Subject: FW: Response To Application Number Y/22/19/PL at Garage Premises Main Road Yapton BN18 0EA

Subject: RE: Response To Application Number Y/22/19/PL at Garage Premises Main Road Yapton BN18 0EA

PROJECT	CLIENT	DATE	DRAWN
Reptune Garage site Main Road YAPTON	P Mountford	Feb 2019	pm
DRAWING	SCALE	DRAWING NO	REV
Block plans as existing and proposed	1:500@A3	1801/07

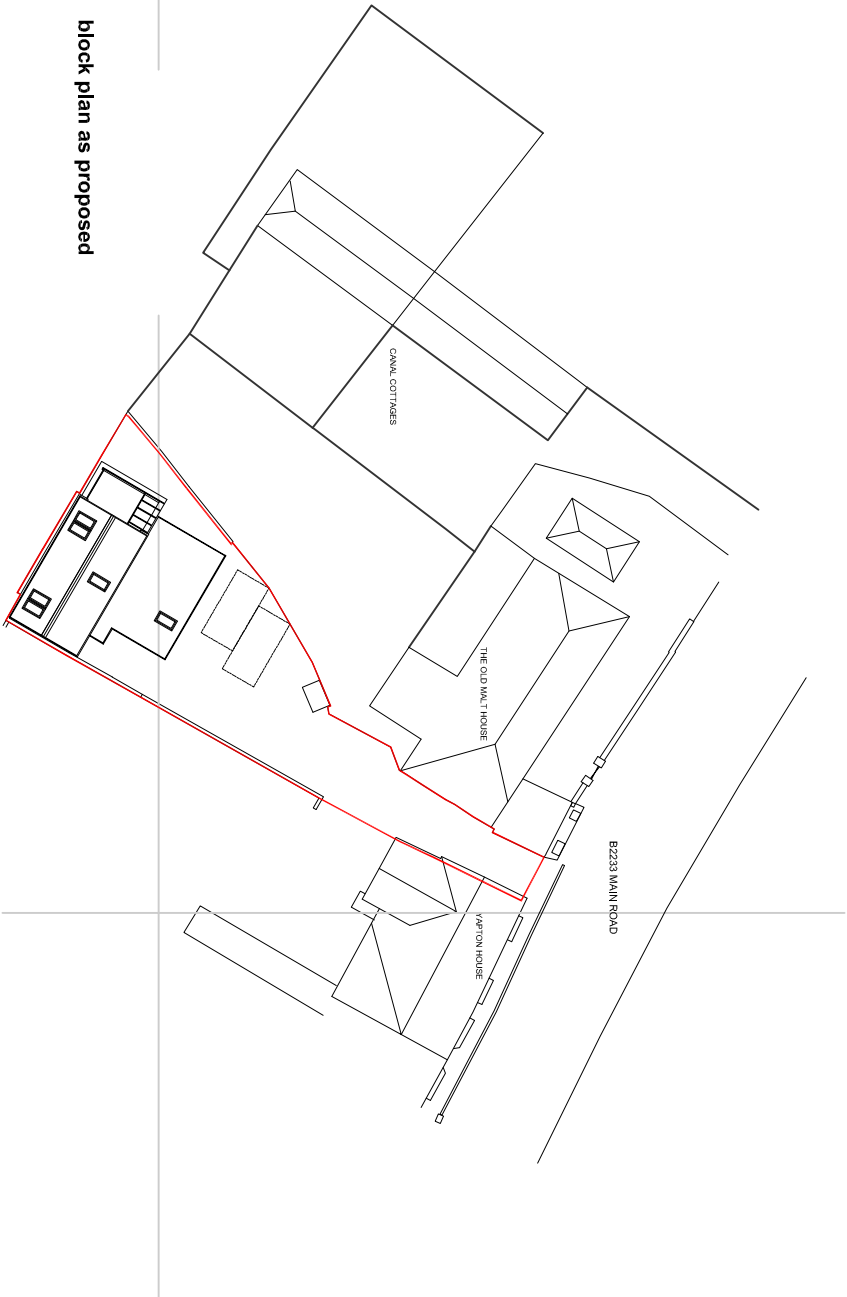
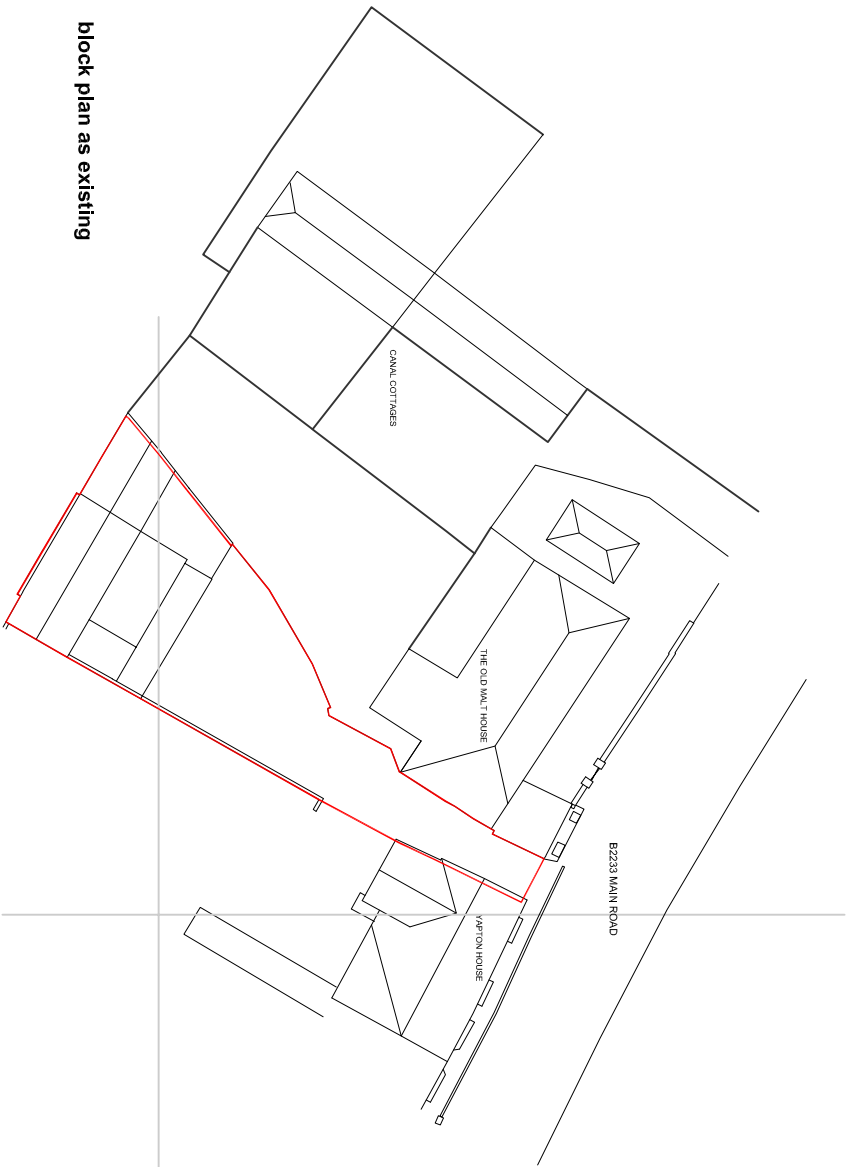
The revised parking arrangement does not appear workable. Whilst it is appreciated that the Design & Access Statement refers to these spaces as being extra-wide to allow for reduced aisle width they have been marked out at 2.4m by 4.8m and the staggered arrangement reduces the available width for turning further. Manual for Streets 2 paragraph 11.1.9 states that 6 metre clear space should be provided for such spaces. Widening and slight relocation of the spaces may improve the manoeuvre to ensure a car can easily turn on site in order to exit on to the public highway in a forward gear. The applicant is advised to demonstrate the workability of any amended parking spaces through swept path tracking.

Further to your email below I attach additional drawing: Reptune-TRK-001 showing swept paths for large cars accessing and exiting both parking spaces whilst the other is in use. This has been achieved by increasing the distance between spaces, as shown on the attached amended plans 1801 02A and 07A. I would be grateful if you could confirm this addresses the concerns raised by the highway engineer.
